July 29, 2021

**Re: MI Treehouse - CAO15-001/VAR18-002  
CORE Project No. 18039**

We have received the City's email comments dated July 23, 2021 for the above referenced project. We have updated the Site Plan and have addressed all applicable comments. Below are our written responses to the City's comments.

Drawing file: CAO15-001 SEP15-001 VAR18-002 / site plan revised 5-8-18.pdf

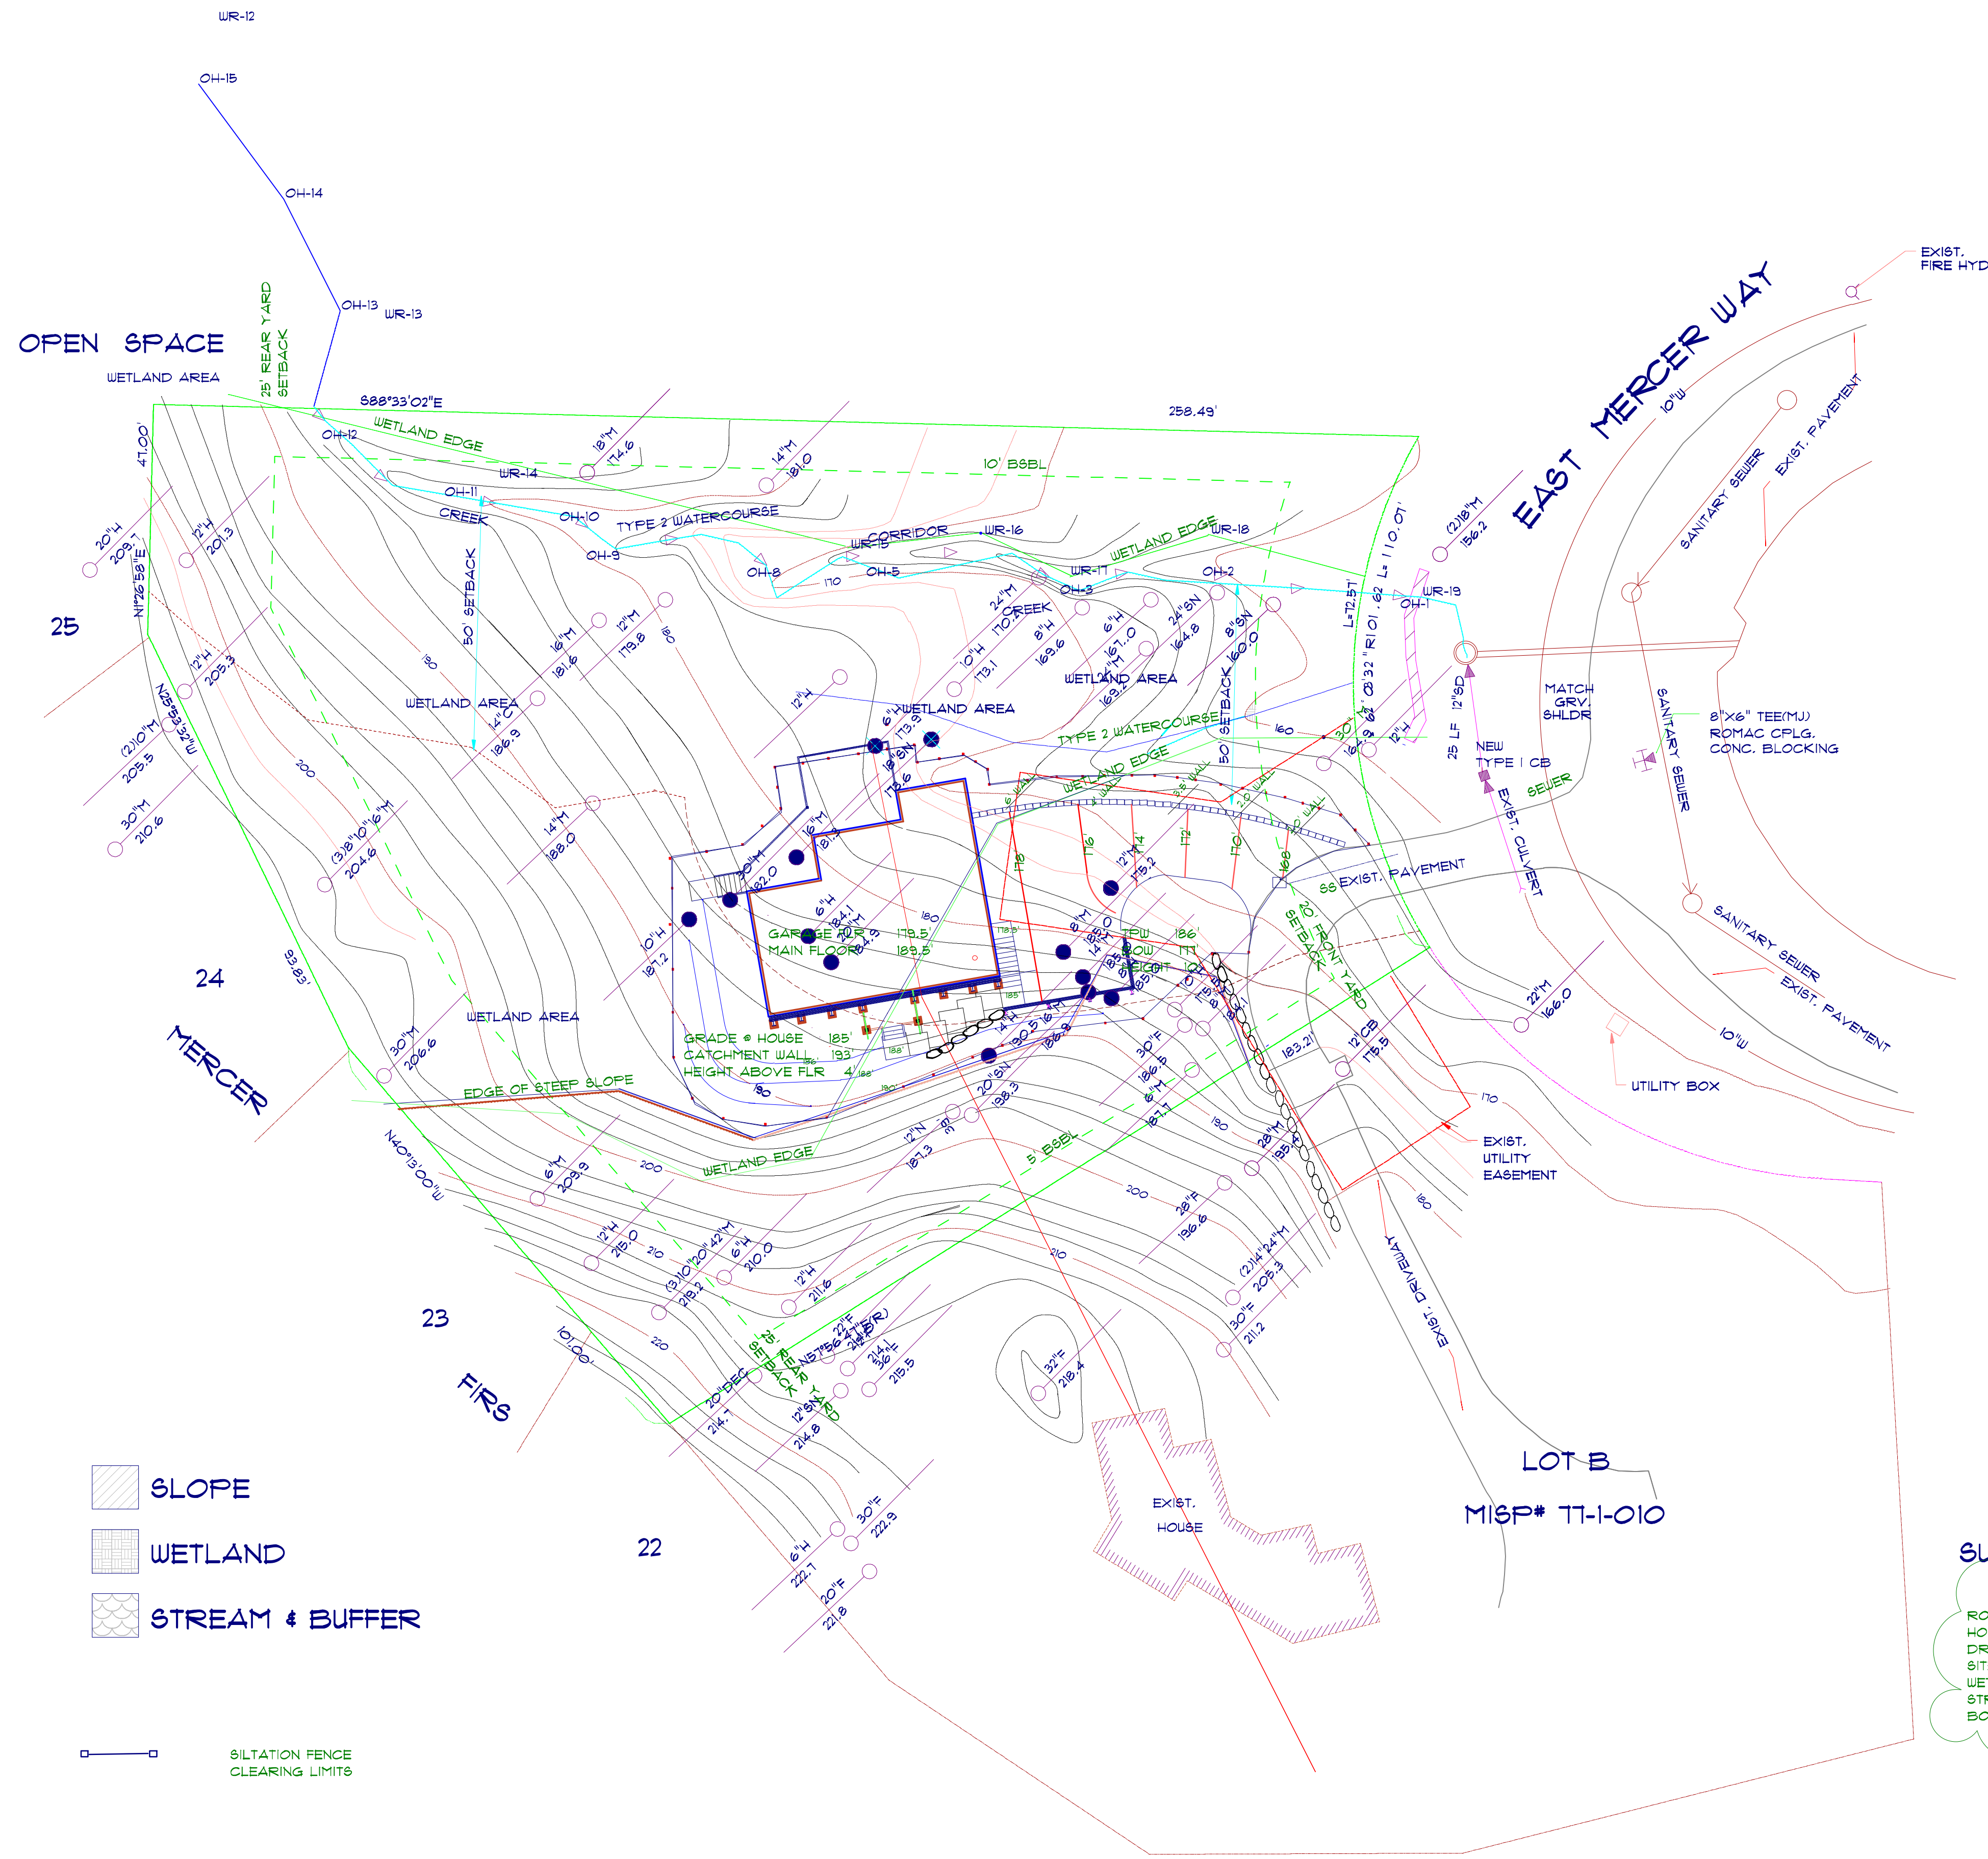
1. Legends on the sheets are incomplete, don't show all items.

2. Various project numbers are provided on different sheets, please include the City's project number.

3. Two foot contours now extend beyond the property line; however, the code requires they extend 50 feet, what has been added varies from about 15 to 40 feet beyond.

4. Error – on C1.02 the legend says “surveyed creek centerline” whereas C4.01 has a callout for the “Stream B OHWM” it should be Stream B OHWM on all sheets.

5. Error – Drawings continue to use the old code term Type 2 Stream rather than Type Np (MICC 19.16.010).

6. All recorded easements should be shown; including the Permanent Stormwater/Utility and Pedestrian Trail Easement (the “2007 Easement”) and the 1978 recorded side sewer easement. A Stormwater/utility & Pedestrian Trail Easement Rec is shown on Sheets C1.01, C1.02, C2.01, and C4.01. But no side sewer easement is shown on any of the Resubmitted Site Plans. If this information is not available please make a note somewhere why it is missing from the drawings and how that will be rectified.

7. Smaller wetland and wetland buffer impact areas are provided, and the drawings have been changed to show a smaller footprint of the house. This is also described in the letter from Courtney Kaylor, but the new/smaller footprint of the house is not provided. Please provide square footage.

***Response: The Site Plan legend has been updated. Please note that there is only one Site Plan for review under the above referenced Reasonable Use Permit application. All other plans are associated only with the Building Permit application on the same parcel and are not subject to review at this time.***

***Response: The Site Plan has been updated to include "Permit Number(s)" as noted. Please also note the general comment under the comment #1 response above regarding the single Site Plan sheet associated with the Reasonable Use Permit for the subject property.***

***Response: The contours shown extend as far as is reasonable without trespassing on private property not owned or controlled by the applicant. Please note also that the intent of the topo extension is provided since what is shown provides additional topographic context well offset from the proposed development footprint.***

***Response: The legend and callouts on the revised Site Plan included with this submittal reference the OHWM of the stream consistently, as noted. Please also note the general comment under the comment #1 response above regarding the single Site Plan sheet associated with the Reasonable Use Permit for the subject property.***

***Response: All references to the stream using old code definitions have been removed from the updated Site Plan included with this submittal. Please also note the general comment under the comment #1 response above regarding the single Site Plan sheet associated with the Reasonable Use Permit for the subject property.***

***Response: All recorded easements applicable to the project parcel are shown. Additional research into the easements as noted on the Title Report Restrictions indicated that the 1978 Side Sewer easement is included in error and is referenced on a different plat. Our research into this matter is documented in an email with corresponding attachment. The easement is still shown on the revised Site Plan because it is still documented in the Title Report for the subject parcel. It is confirmed, however, that there is no such side sewer easement applicable to the plat that established the subject (and adjacent) parcel.***

***Response: The revised Site Plan included with this submittal includes a building footprint square footage as noted. Please also note the general comment under the comment #1 response above regarding the single Site Plan sheet associated with the Reasonable Use Permit for the subject property.***
